Ribble Valley Borough Council
Church Walk,
Clitheroe,
BB7 2RA

Phone: 0300 123 6780
Email: lhscustomerservice@lancashire.gov.uk
Your ref:
Our ref: LHS/CS/3/2016/0309
Date: 27th April 2016

Proposal:	Erection of one new dwelling house (resubmission of application 3/2016/0034)
Location:	Land adjacent to 2 Harewood Avenue Simonstone BB12 7JB
Grid Ref:	377106 - 434576

LOCATION & SITE PLAN
OF
LAND AT 2 HAREWOOD AVE
SIMONSTONE
FOR
MR & MRS M LANGLEY

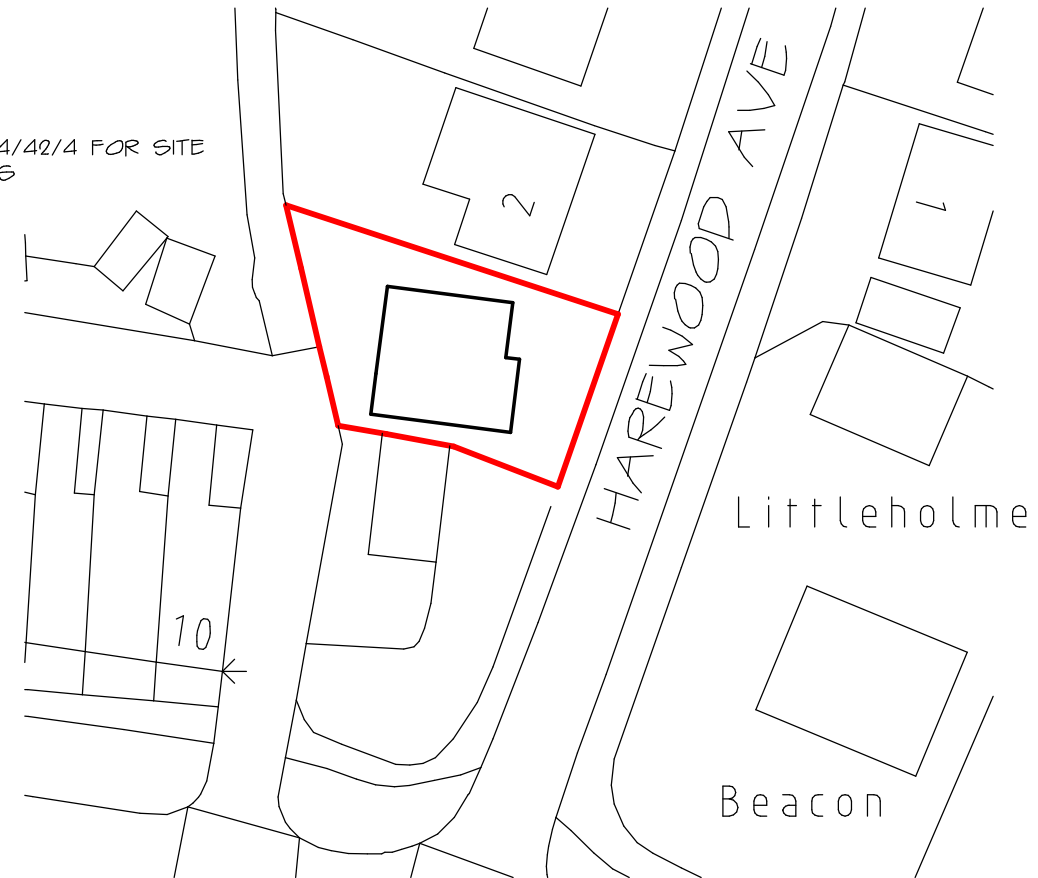
Based on the car parking recommendations in the Joint Lancashire Structure Plan and the Highway Development Control Section is of the opinion that the applicant has provided adequate off-road parking provision for this type and size of development.

The new vehicular access, within the adopted highway fronting the property will need to be constructed under a section 184 agreement of the 1980 Highways Act (Vehicle crossings over footways and verges); The Highway Authority hereby reserves the right to provide the highway works within the highway associated with this proposal. Provision of the highway works includes design, procurement of the work by contract and supervision of the works. The applicant is advised to contact the Environment Directorate before works begin on site. Further information and advice can be found at www.lancashire.gov.uk and search for vehicular crossings.

1. No part of the development shall be commenced until all the highway works within the adopted highway have been constructed in accordance with a scheme that shall be submitted to and approved by the Local Planning Authority in consultation with the Highway Authority as part of a section 184 agreement, under the Highways Act 1980. Reasons: In order to satisfy the Local Planning Authority and Highway Authority that the final details of the highway works are acceptable before work commences on site and to enable

- all construction traffic to enter and leave the premises in a safe manner without causing a hazard to other road users.
2. The car parking and manoeuvring scheme to be marked out in accordance with the approved plan, before the use of the premises hereby permitted becomes operative and permanently maintained thereafter. Reason: To allow for the effective use of the parking areas.
